**Re: Pitre Kia Westside Auto Dealership
9640 EAGLE RANCH RD NW
Conceptual Traffic Circulation Layout for DFT Approval
Engineer's Stamp 11-6-24 (B13D002D)**

The conceptual TCL submittal received 12-11-2024 is approved for DHO and/or DFT submittal. When submitting this project through the building permit process, a full Traffic Circulation Layout will need to be submitted and approved prior to building permit. **When submitting TCL for building permit approval, please ensure that:**

KIA_WESTSIDE AUTO_DEALERSHIP	ENGINEER'S SEAL RONALD R. BOHANNAN NEW MEXICO 7868 PROFESSIONAL ENGINEER 06/18/25 RONALD R. BOHANNAN P.E. #7868	DRAWN BY MR DATE 06/18/2025
	FINAL TRAFFIC CIRCULATION PLAN	SHEET # TCL-1	JOB # 2024019

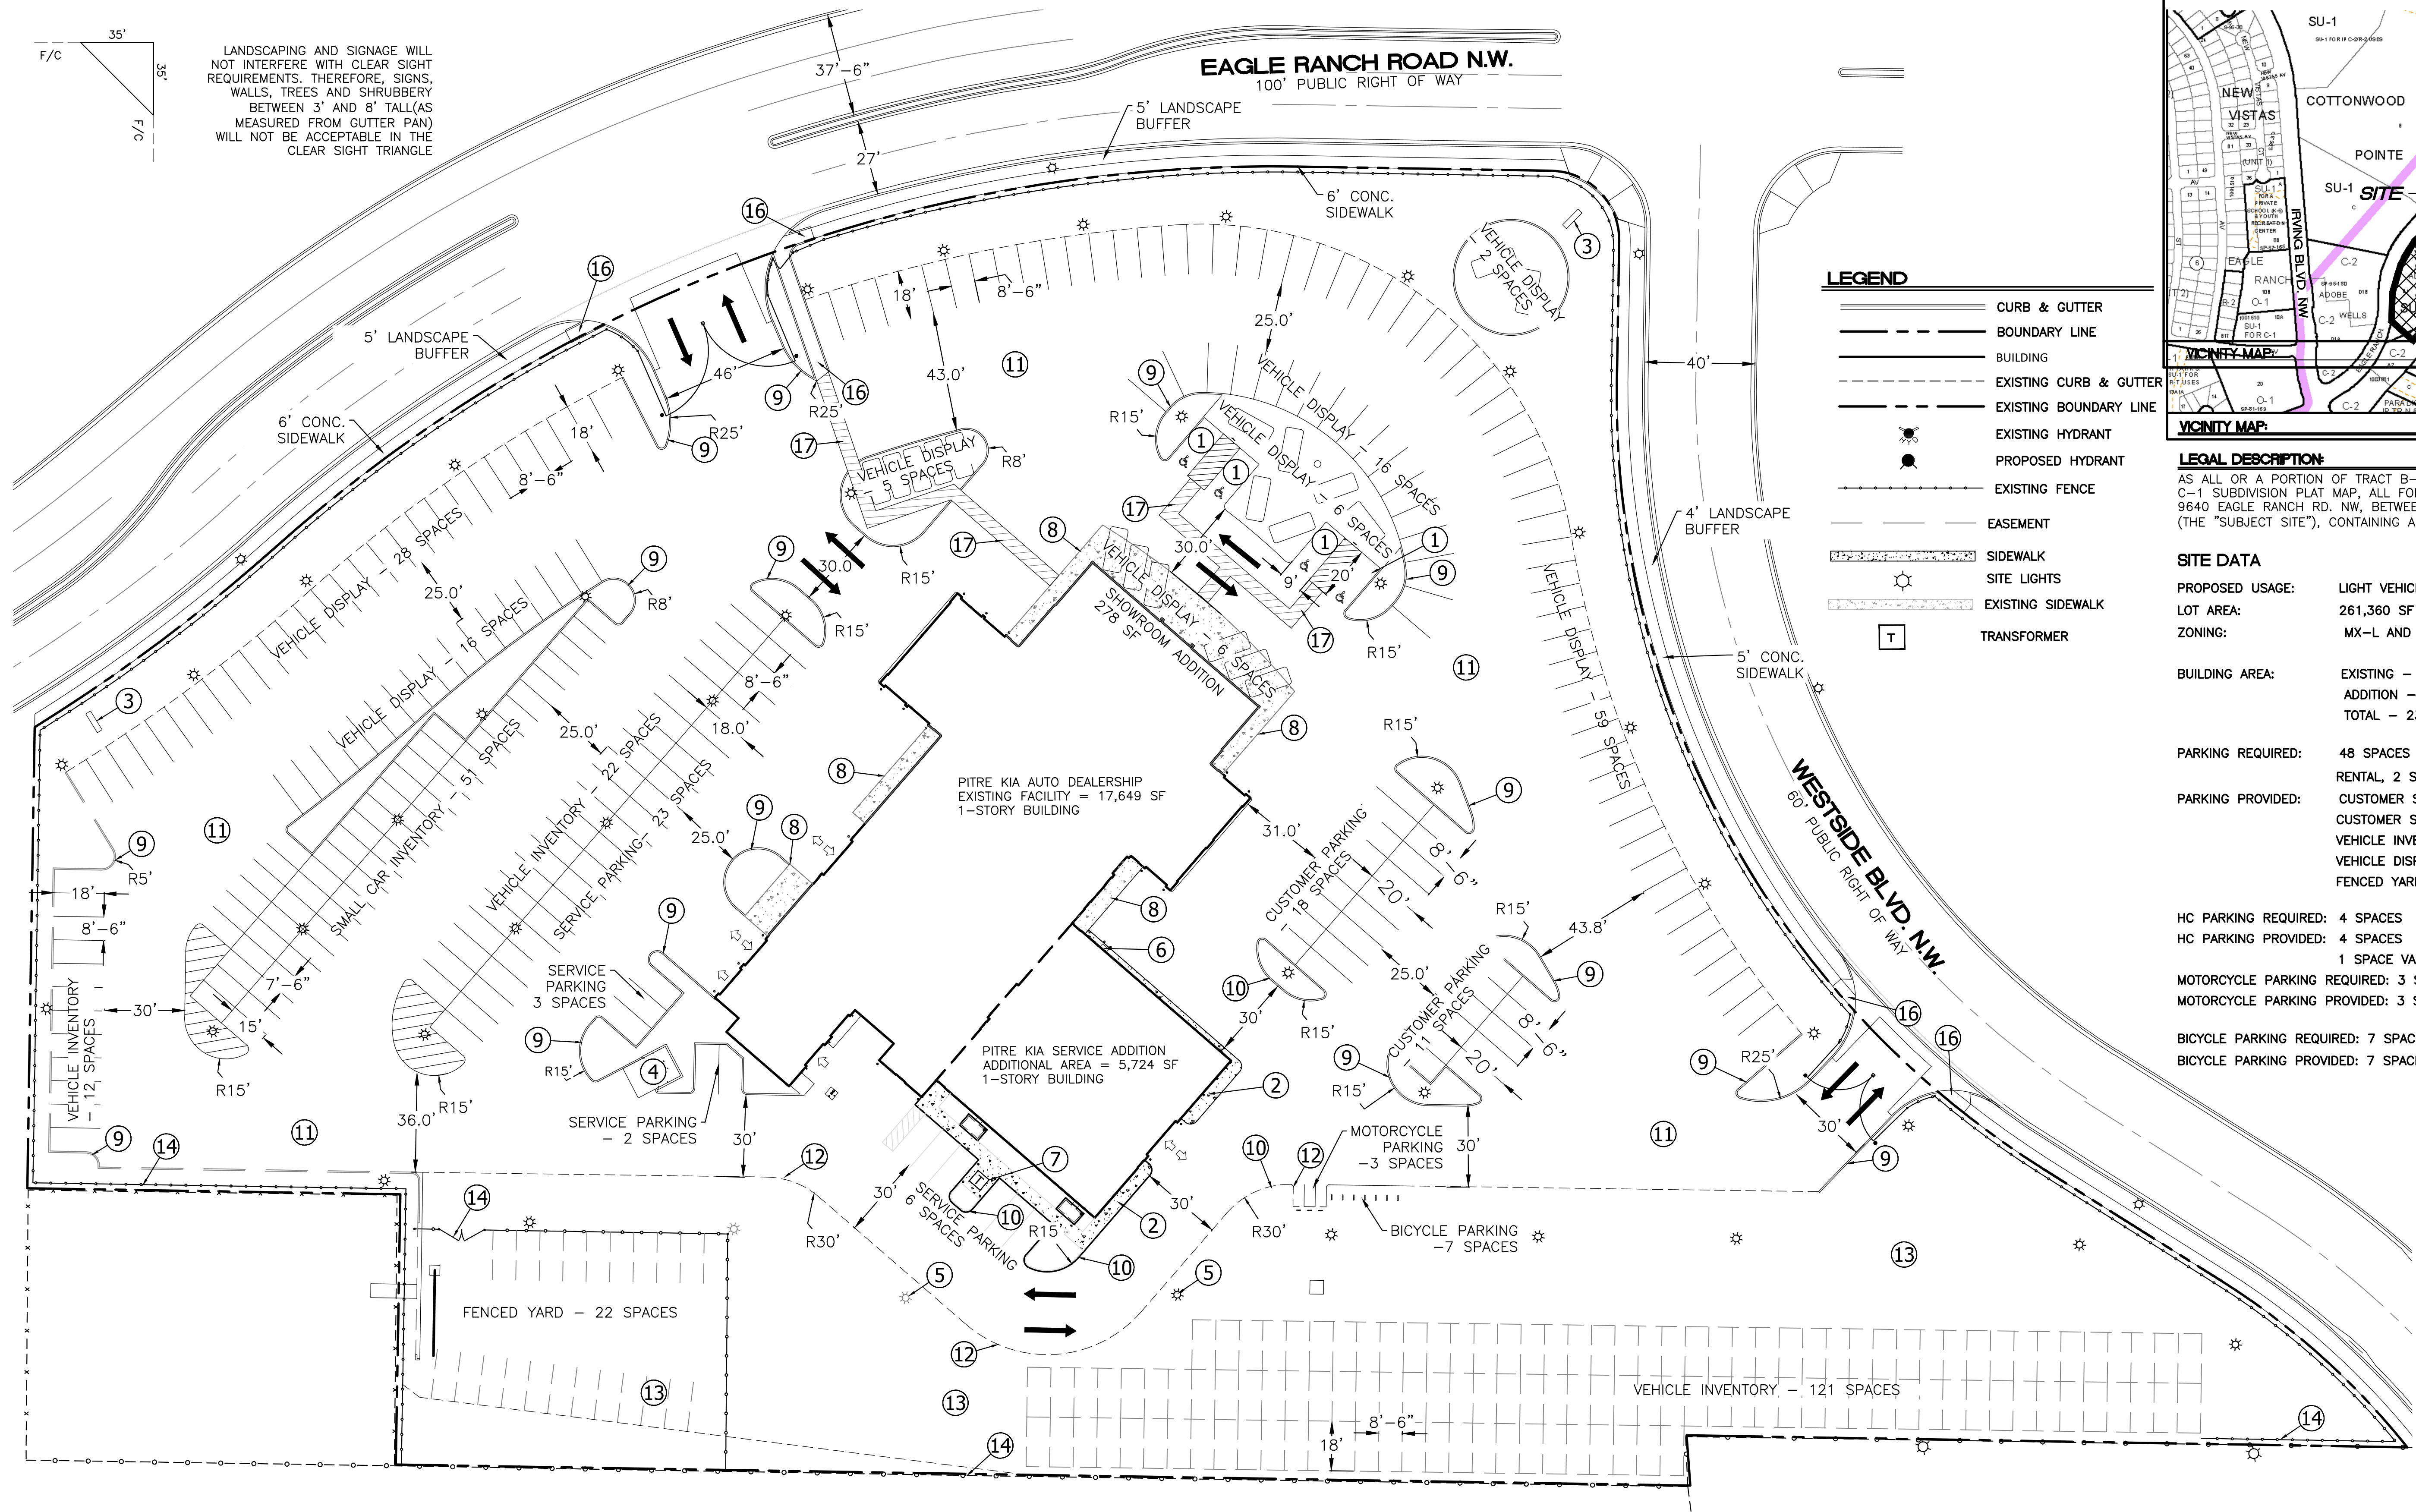
- 1-Pedestrian access width keyed note 17 is 6 ft**
- 2-Show the widths of sidewalk and buffer along both streets**
- 3-upgrade the accessible ramps at the entrances**
- 4-Add a keyed note stating to replace any broken sidewalks.**
- 5-provide approval of fire marshal and solid waste dept.**
- 6-submit TSF (see attached)**
